Our Ref: SDNP/21/00774/ADJAUT
Contact Officer: Karen Wooden

Neighbouring Authority Consultation

Proposal: Adjoining Authority Consultation - Proposed 2 storey front extension and loft conversion.

Address: 14 Queens Lane , Arundel , BN18 9JN, ,

SECOND FLOOR PLAN 1:50 RT A1

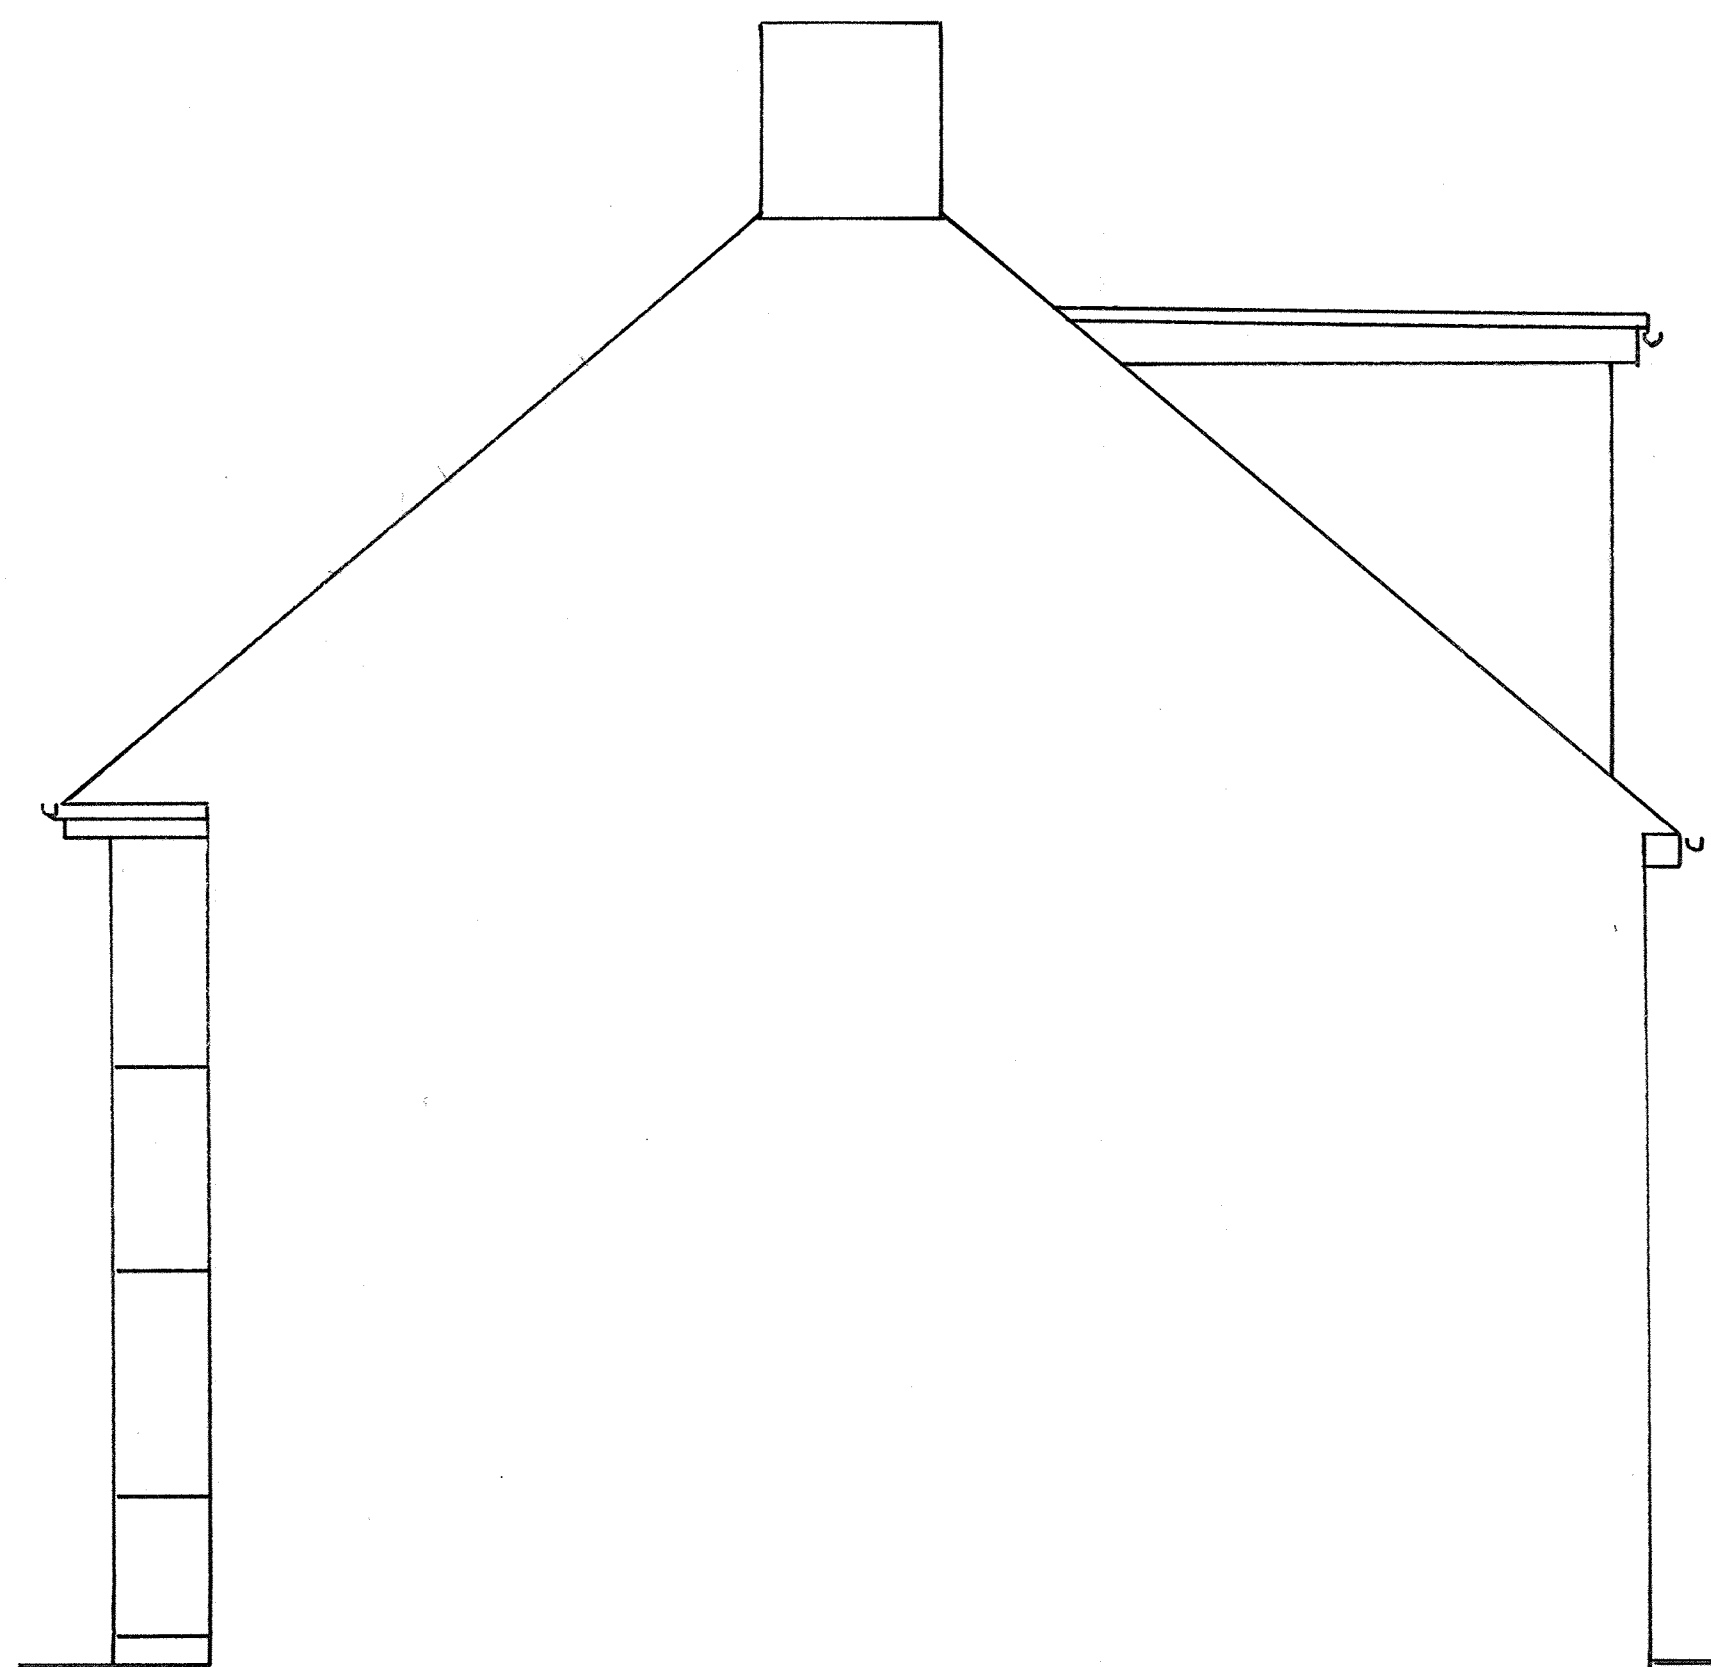
The application form confirms the proposed materials to be brick and tiles. These should be of a similar appearance to those used on the host dwelling. The front extension and loft conversion

are considered to be of an appropriate scale and design, and are not considered to cause significant harm to the visual amenity of the National Park.

ROOF PLAN 1:100 RT A1

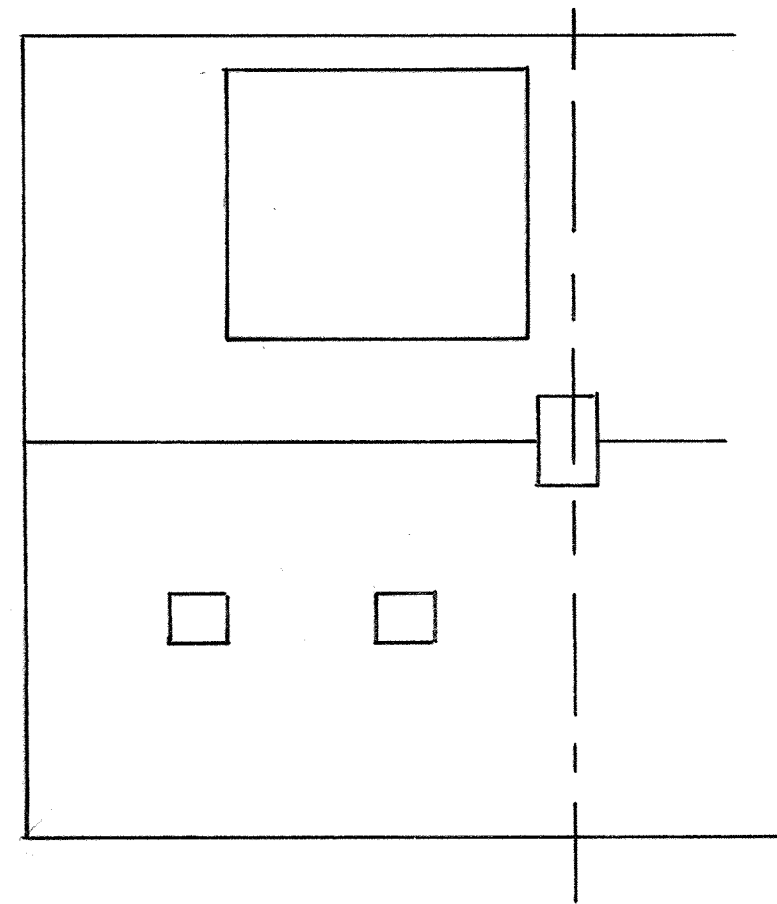
The SDNPA has been successful in achieving Dark Skies Reserve status for the South Downs National Park - only the second such Reserve in England. For further information, please see <https://www.southdowns.gov.uk/enjoy/dark-night-skies/>. It is recommended that a condition be included to ensure the proposed rooflights include low transmittance glazing and timed blackout blinds.
